## Consultee Comments for Planning Application 2025/90577

Application Number: 2025/90577

Address: land off Cowrakes Road, Lindley, Huddersfield, HD3 3SS

Proposal: Variation conditions 4, 5 and 7 (landscaping) on previous permission 2013/90204 for erection of 42 dwellings, formation associated site access, and drainage and landscaping works

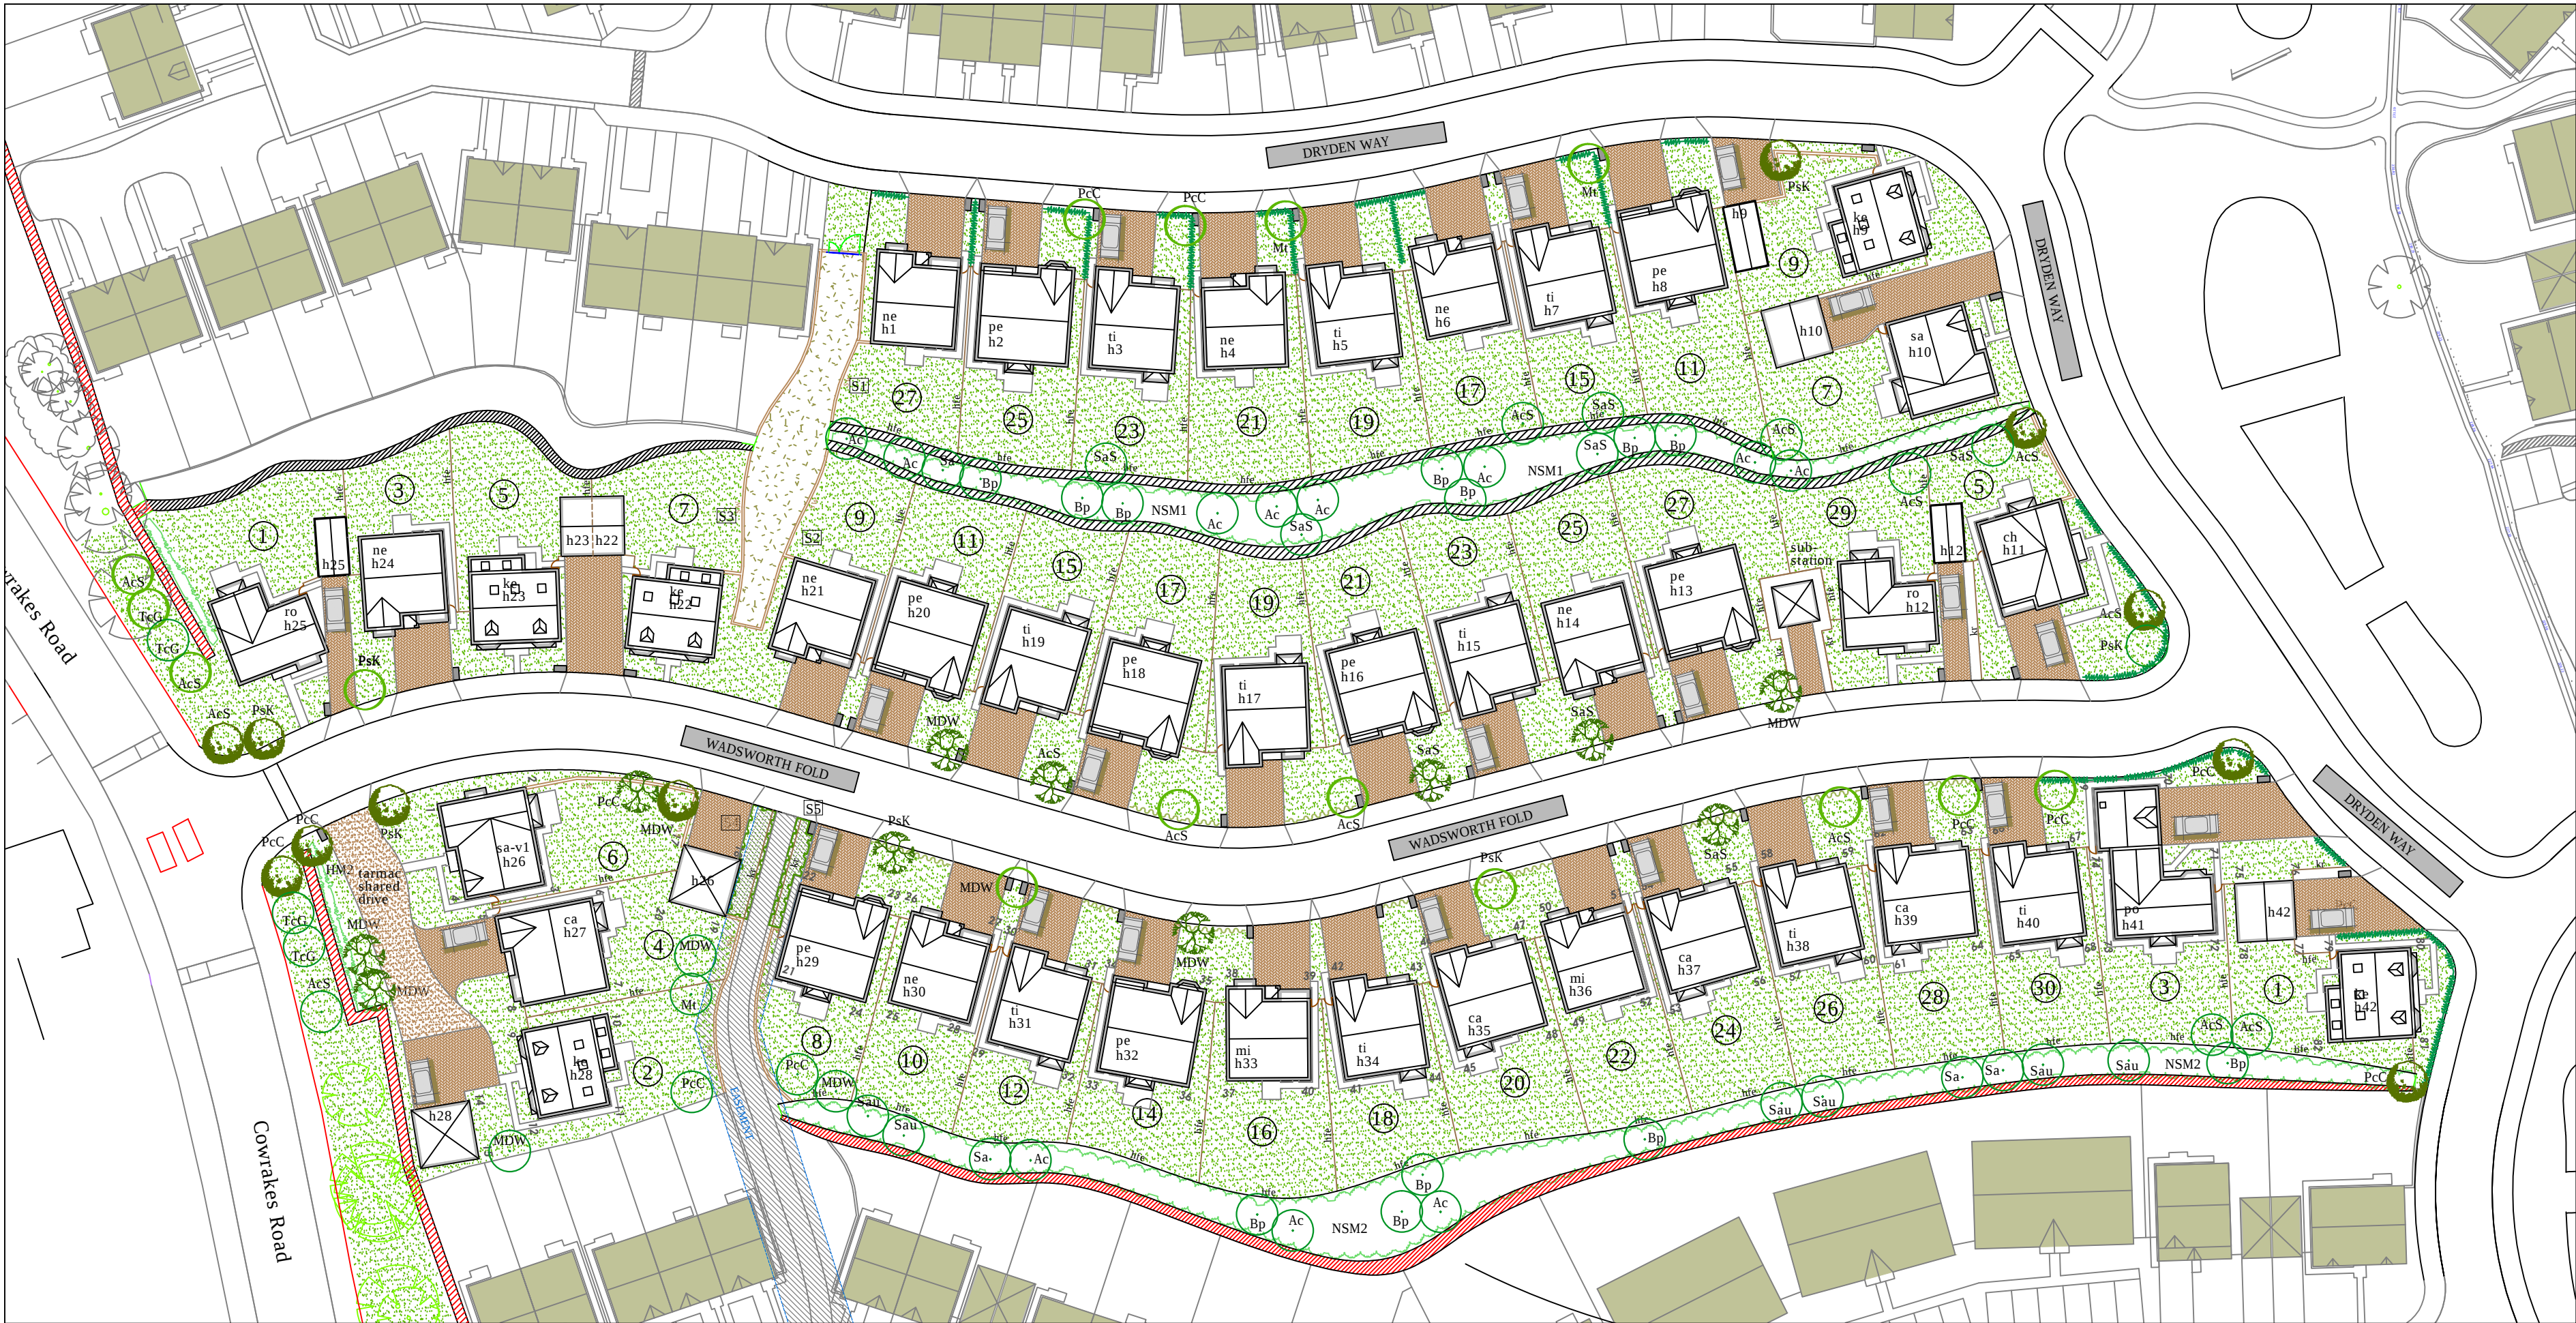
As per the Covering letter [id 1079362], the applicant proposes to omit a footpath between Dryden Way and Wadsworth Fold; the area is to be reseeded with a wildflower mix instead.

In my assessment, a footpath connecting Wadsworth Fold and Dryden Way would not meet any of the above criteria.

Additionally, in line with Crime Prevention Through Environmental Design, opportunities for access, egress and through movement should be minimised to prevent unauthorised access. Furthermore, the natural surveillance of the proposed footpath appears limited.

The footpath would increase the site's permeability and vulnerability of the properties in the immediate vicinity, increasing opportunities for acquisitive crime and antisocial behaviour.

I also have concerns about the safety of the proposed footpath- the land is indeed on a steep slope, the footpath itself would be narrow and unlit.

**West Yorkshire Police support the application to omit the footpath and retain the land as landscaped.**
